Our ref: DOC19/913151
Senders ref: SSD-9472

Subject: EES comments on the Environmental Impact Statement for Sikh Grammar School –
SSD-9472 - 151-161 Tallawong Road, Rouse Hill

Subject: EES comments on the Environmental Impact Statement for Sikh Grammar School – SSD-9472 - 151-161 Tallawong Road, Rouse Hill

FIGURE 6

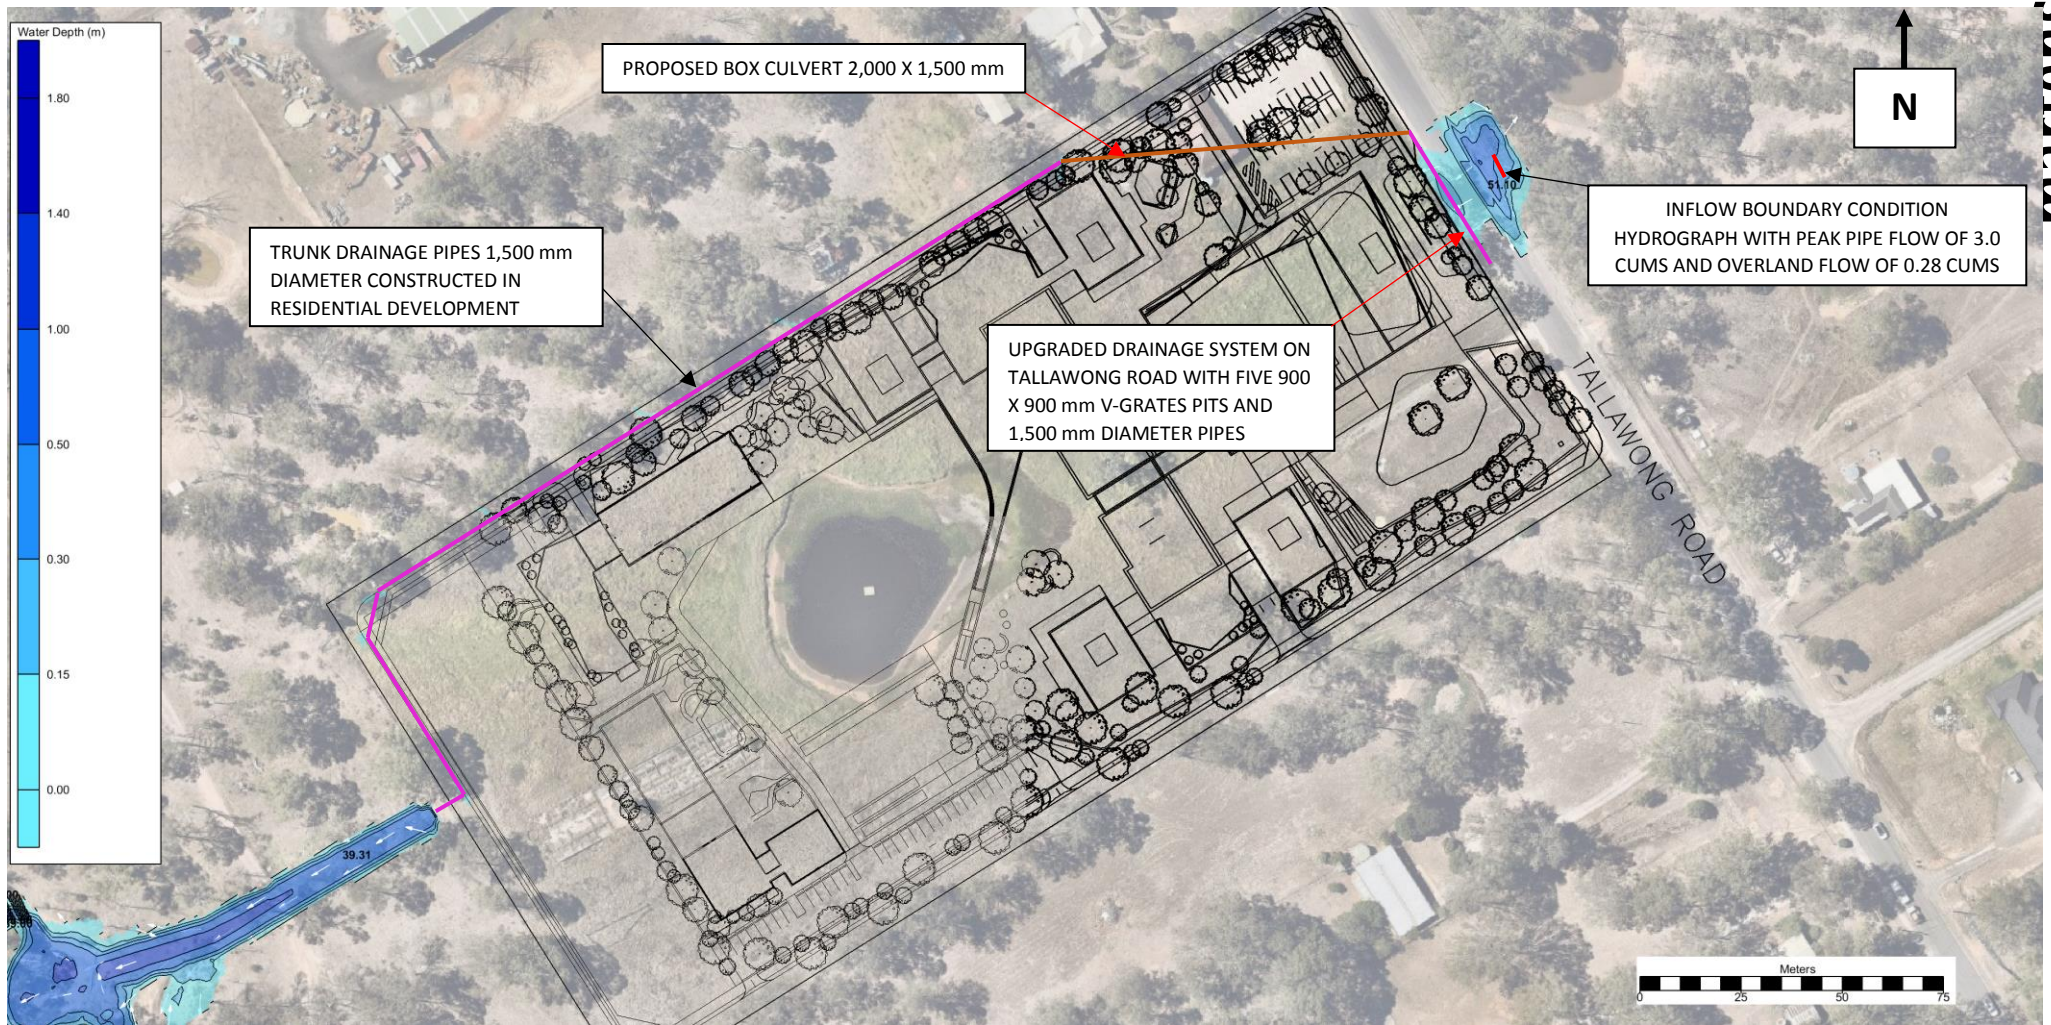
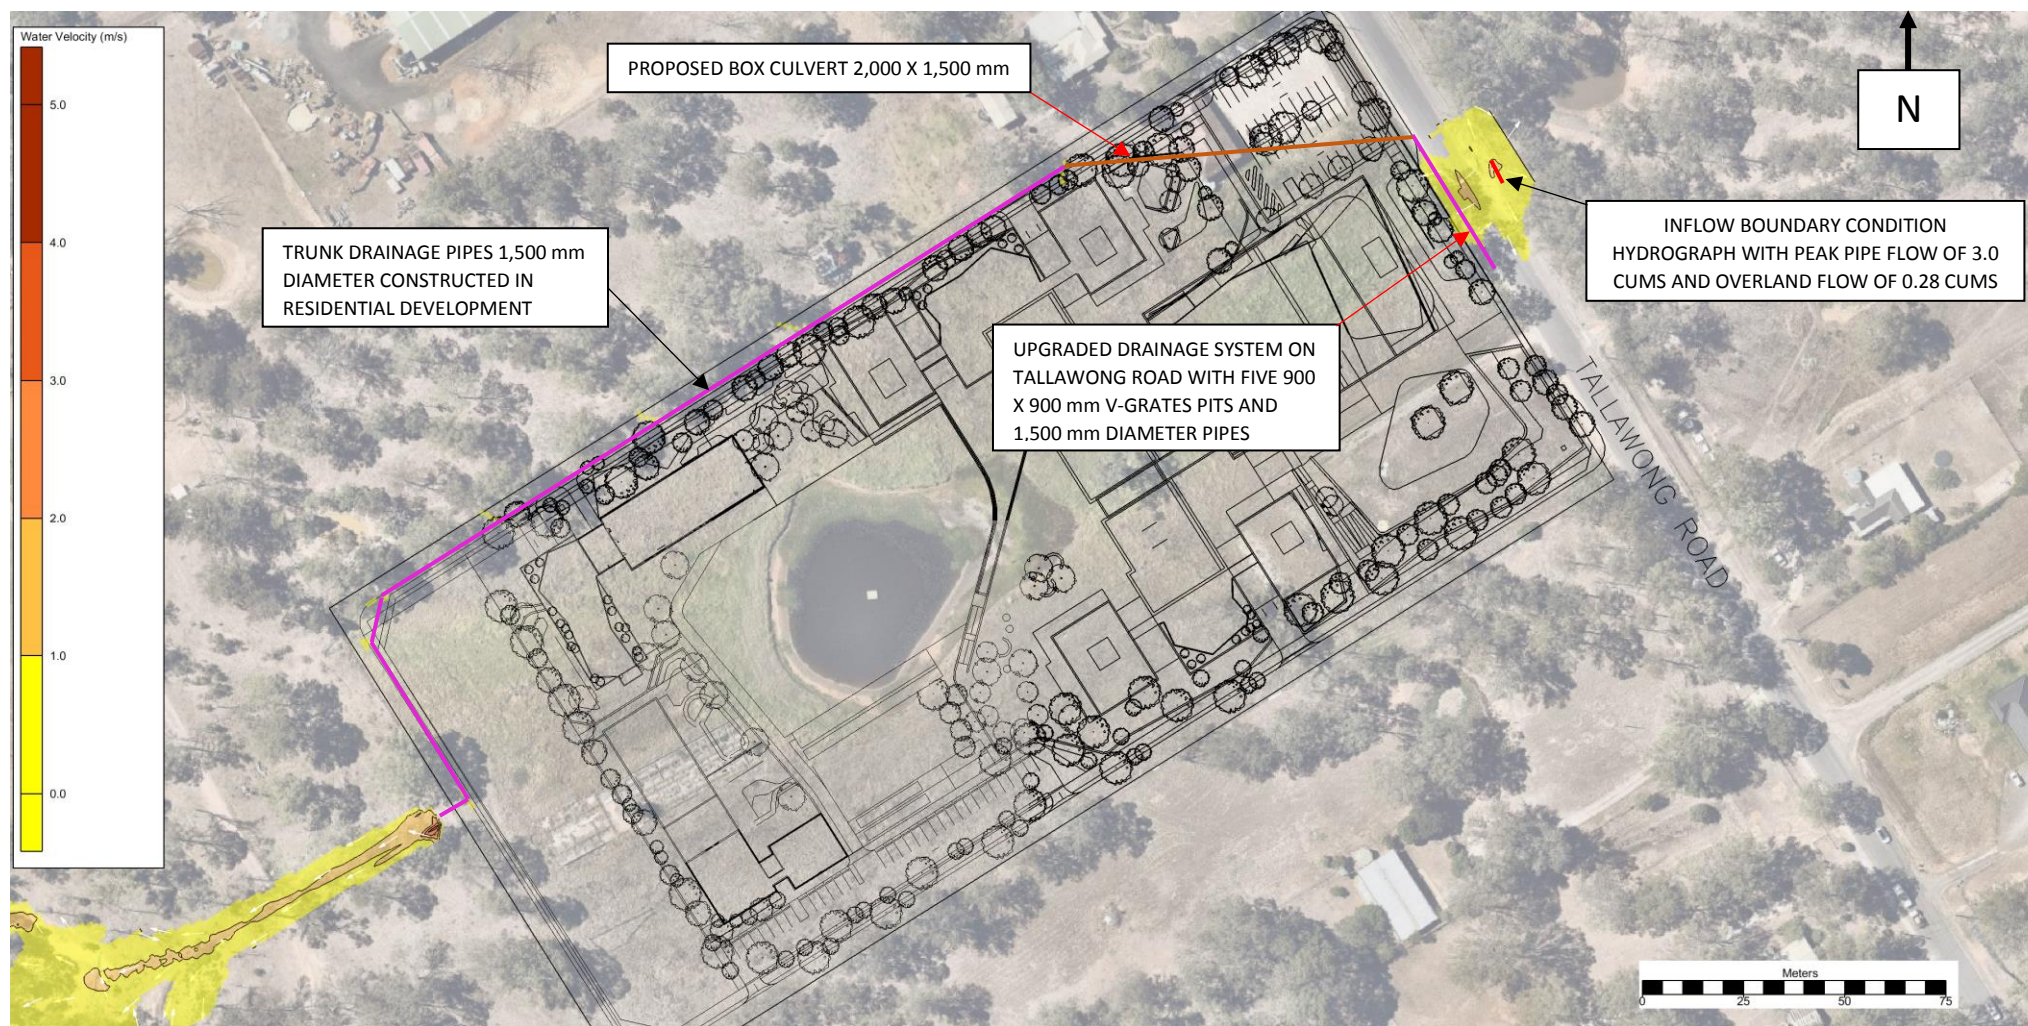
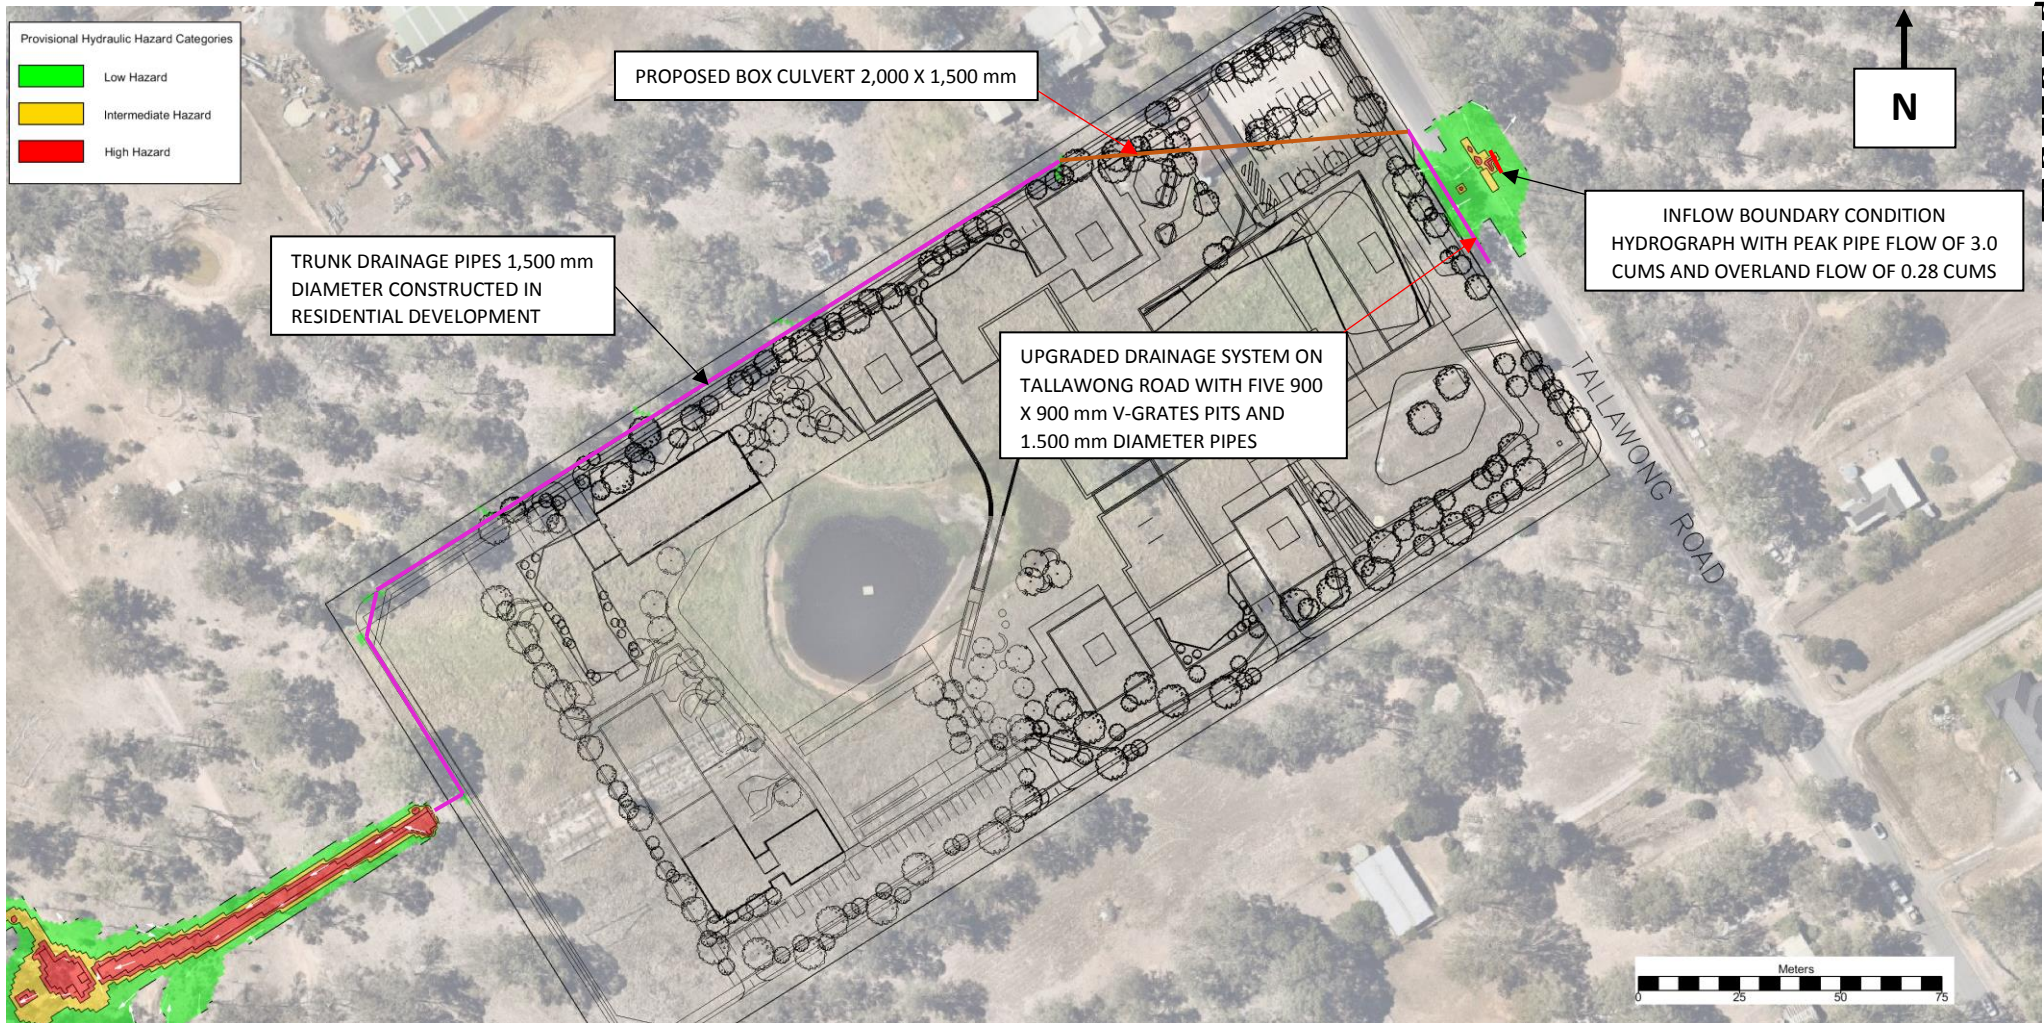
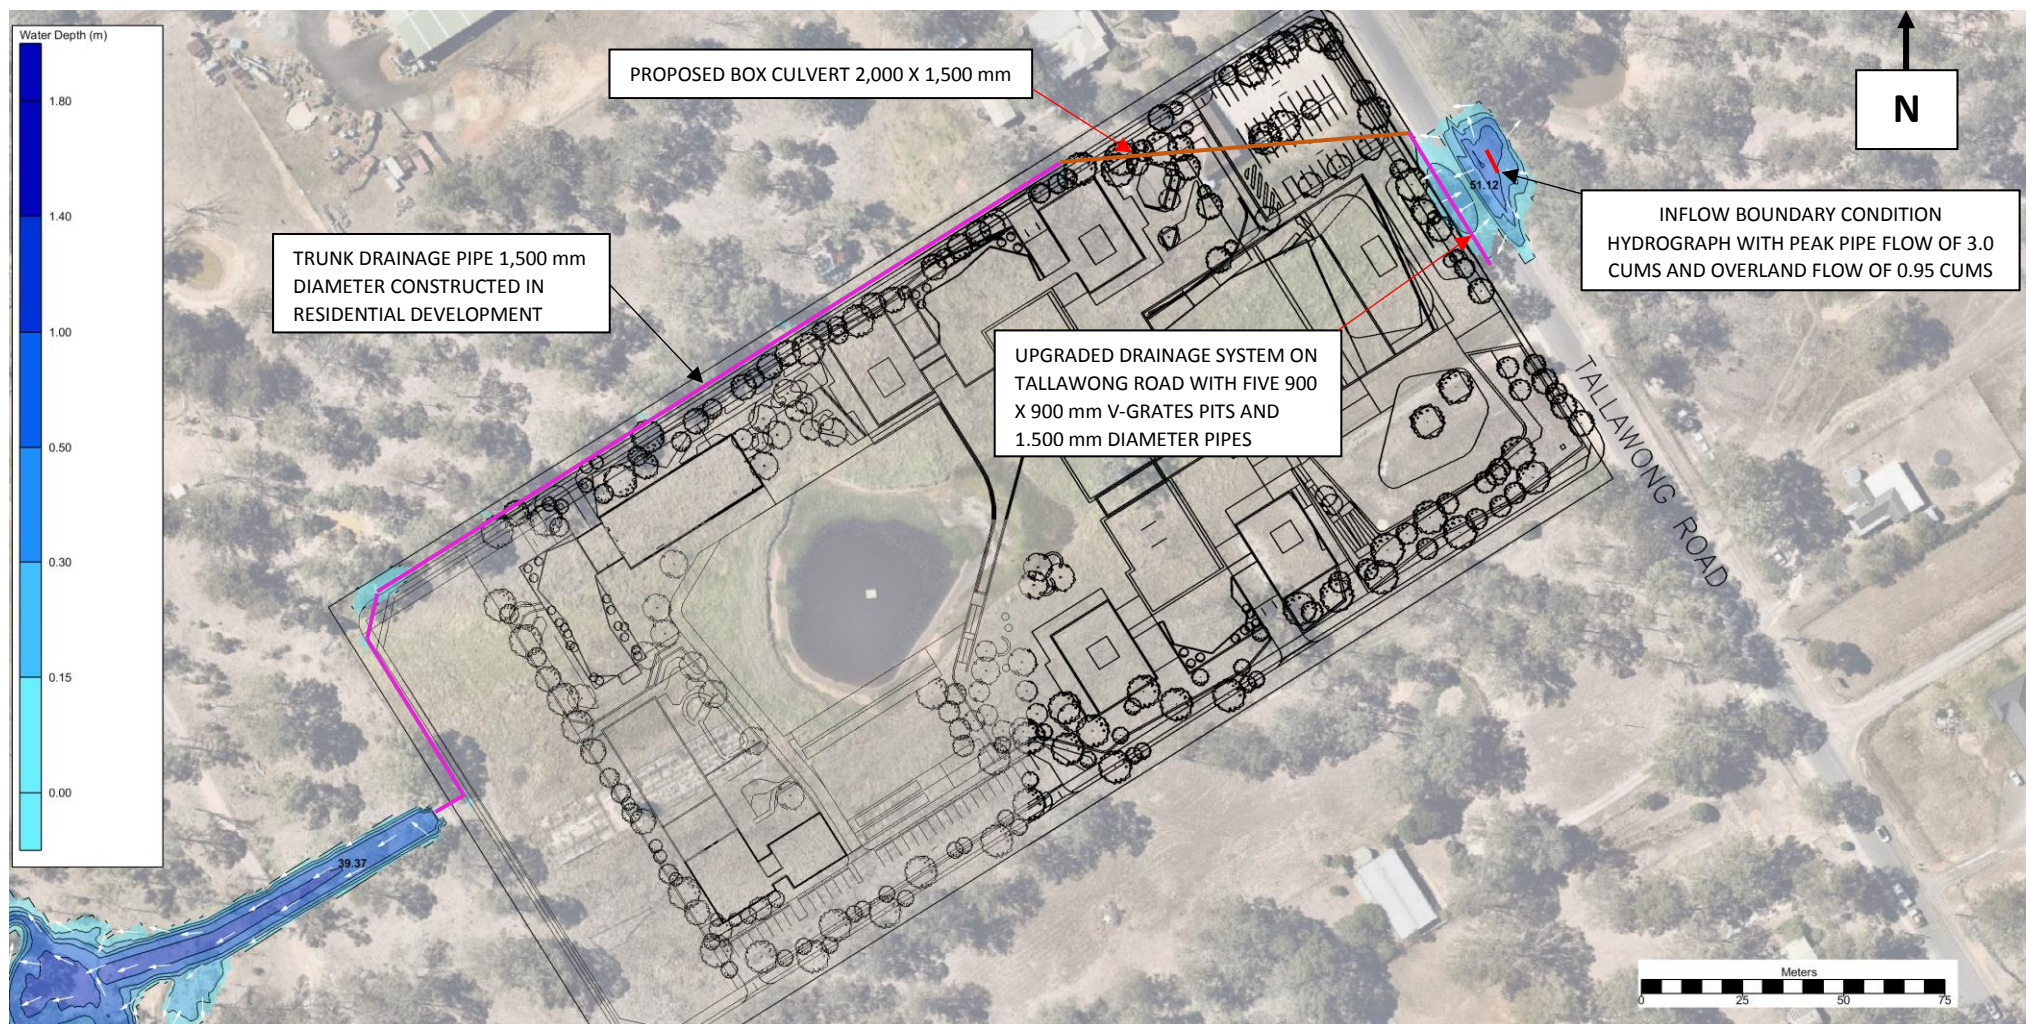
- Figures 3 to 5 of the report shows the site is significantly impacted by the 1% AEP in existing condition. Figure 6 to 11 shows no impact by the 1% AEP in the proposed condition due to the proposed drainage system.

- The report does not provide information whether the project results in any adverse impacts on adjacent and neighbouring properties. These impacts should be addressed and documented.
